# PLANNING BOARD REPORT

Commercial Development including gas station and convenience store with ATM

2282 Congress Street

Project ID #2013-086

PLAN 8

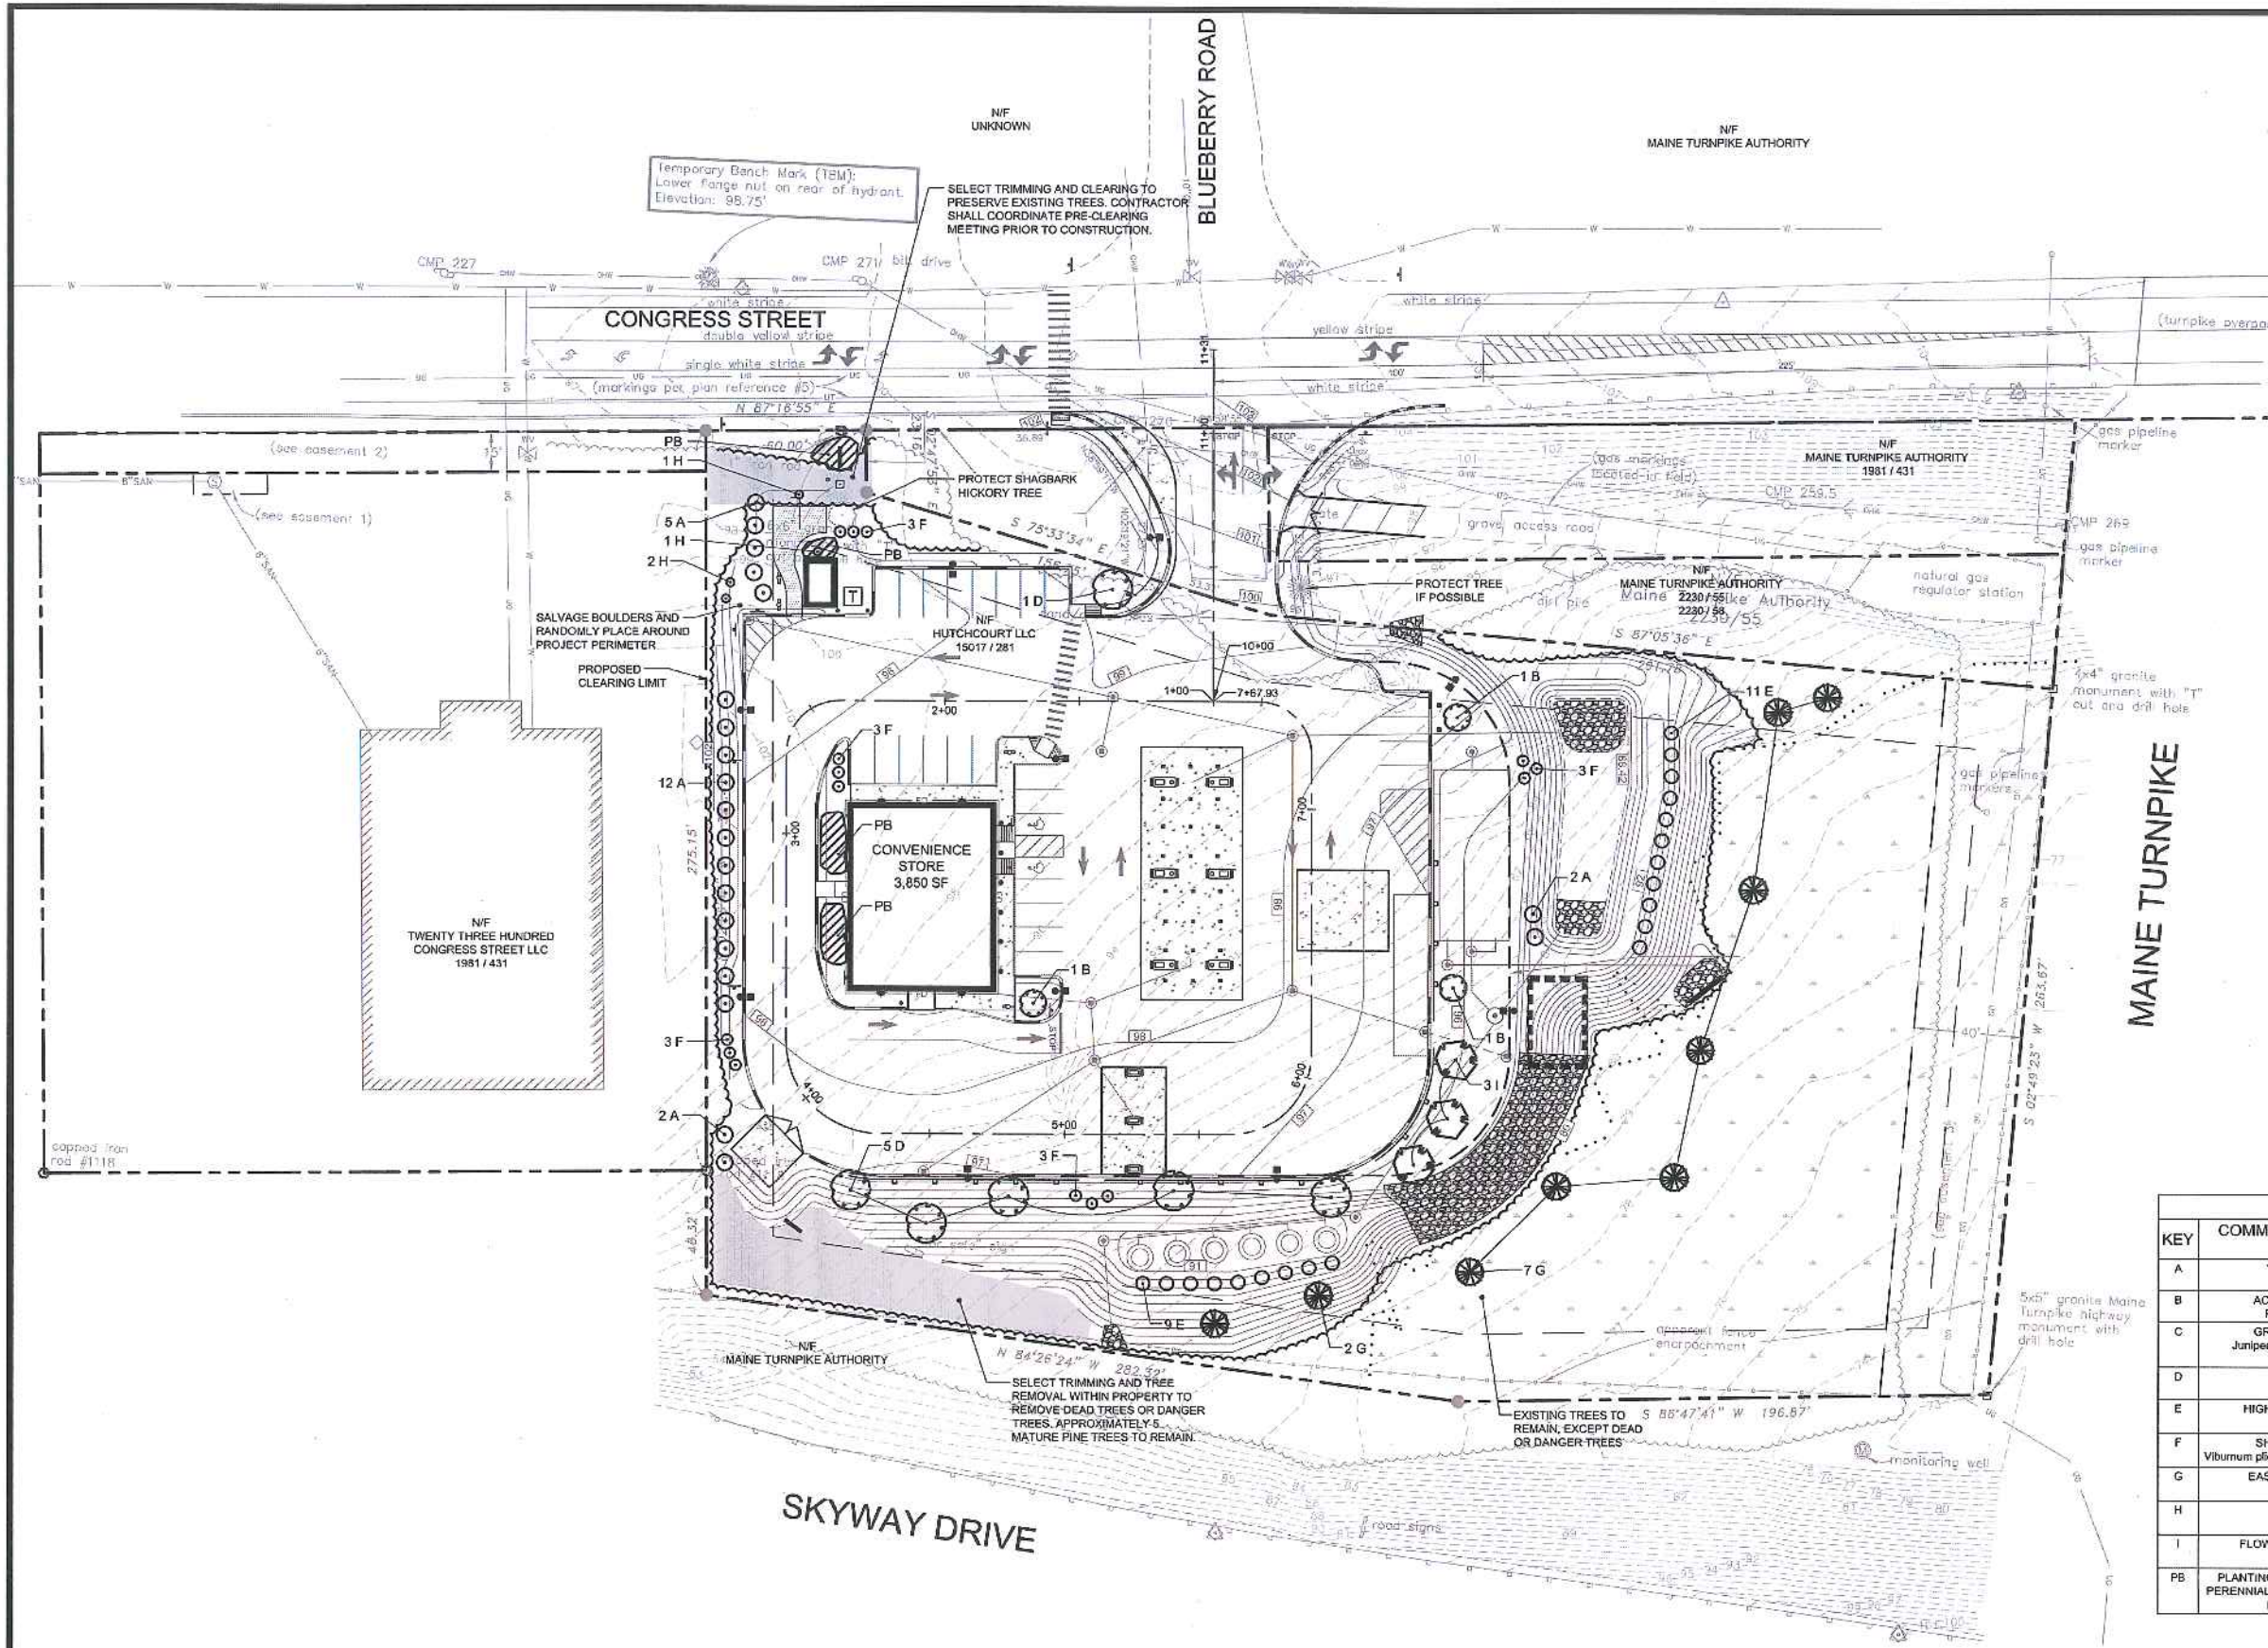
The final Landscape Plan (Plan 8) reflects a number of improvements (relocation of the dumpster; addition of the farmstand and landscaped area near Congress Street, more extensive buffer planting). However, the City Arborist, Jeff Tarling, has two small recommendations to address both the CZA objective of achieving a “campus like character” and the site plan ordinance requirements for retaining trees (Attachment 8):

*a) Tree Save - the 'tree-save', tree thinning area along Congress Street is improved and meets our recommendations. Additional 'tree-save' areas along the Western property line and towards Skyview Drive will need to be marked prior to site work and as approved by the City Arborist. There may be trees to be thinned or removed due to poor condition or risk. (Thinning trees for views is not recommended - thinning trees for safety and condition is.) Standard tree protection measures shall be used during construction, these include protection of tree root zones, identifying trees to protected, construction fencing or tagging where needed. No storage of equipment or construction materials in tree protection root zone areas. The area around the Shagbark Hickory is one of the tree protection zones.*

*b) Trees in parking lot - In the area shown as snow storage, and addition one to two trees could be set back away from the edge of pavement to still allow snow clearing and meet the parking lot tree / shrub standards.*

*Overall the landscape plan is acceptable as shown with the recent improvement and suggested conditions.*

CANOPY ELEVATIONS
A2

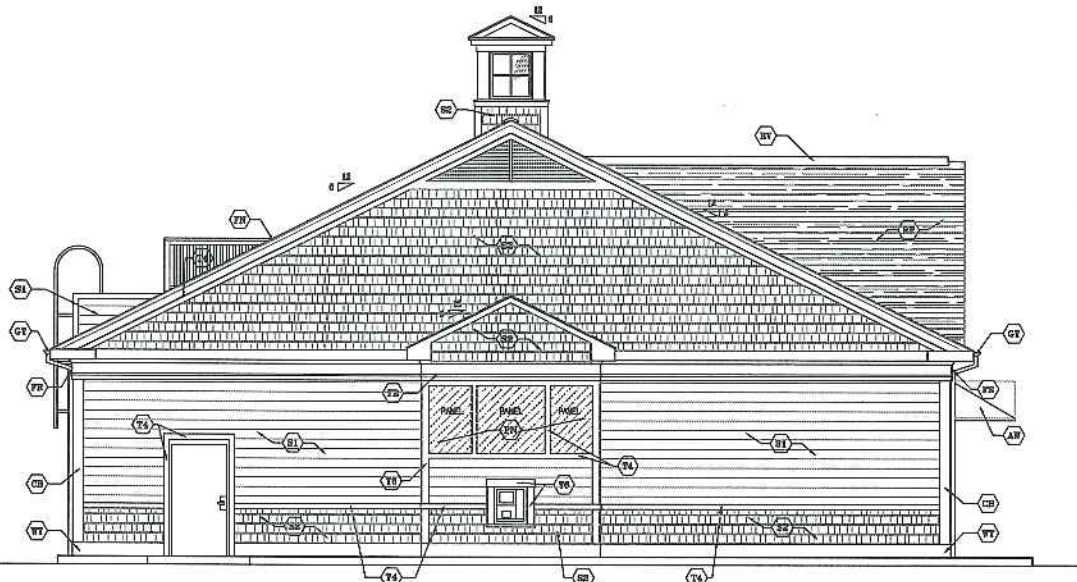
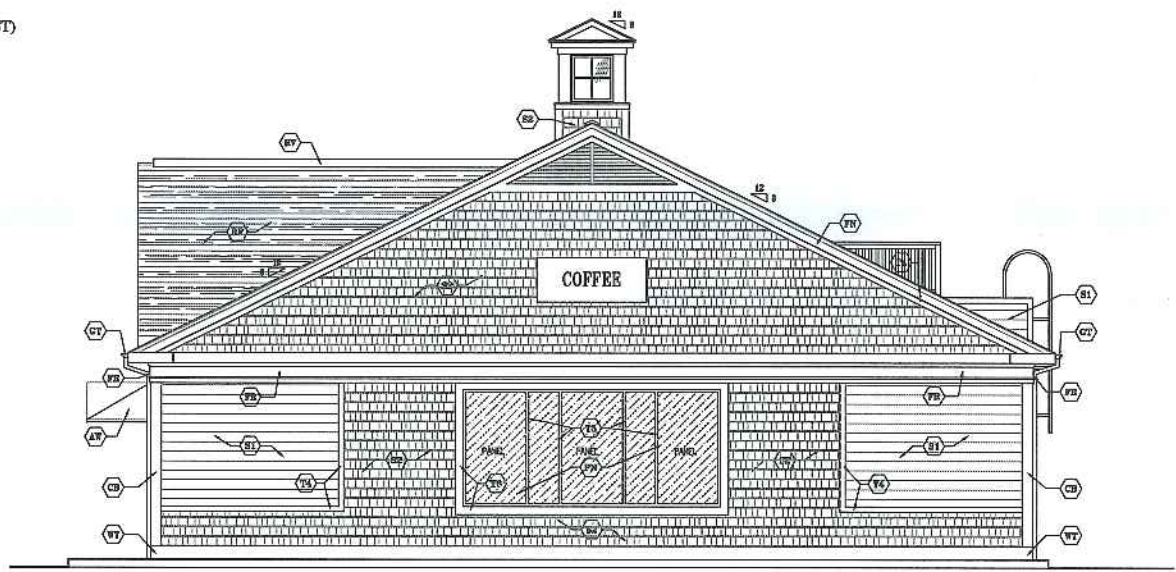
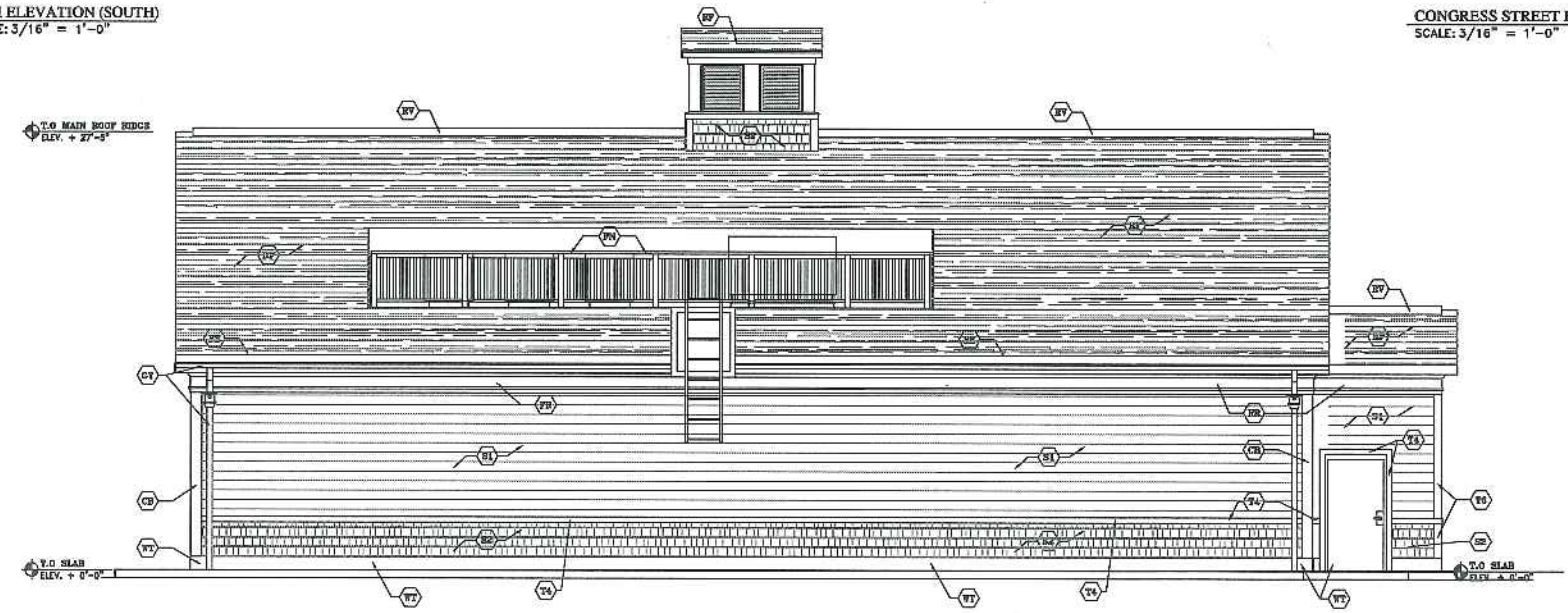
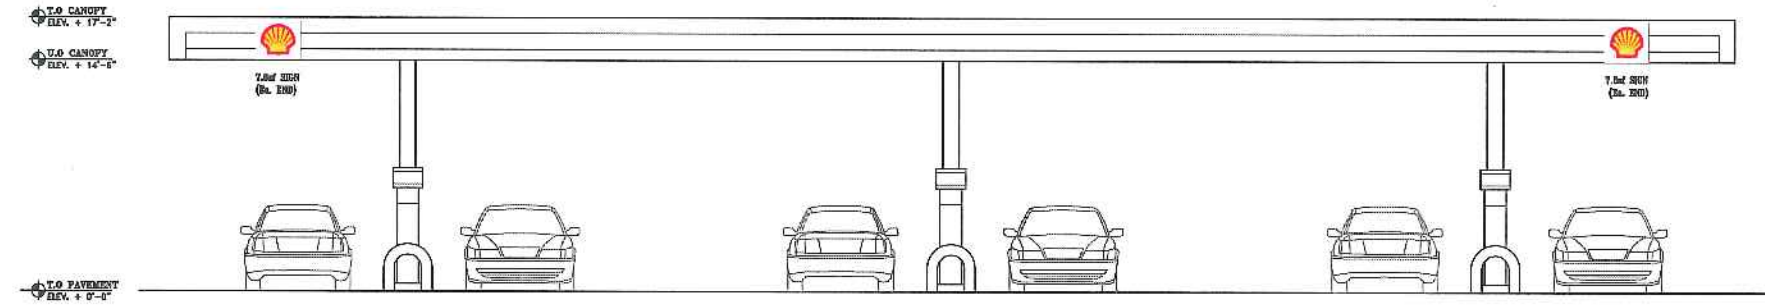
Staff comment: The proposed architecture (Plans 25 and 26) appears to be consistent with a campus like character. Board will need to consider whether the landscaping (which staff recommends should be augmented near the truck parking area) and the light fixture ("Prolific", see Attachment I.4) is consistent with the aim to achieve a campus like character (both discussed in Site Plan Review below)
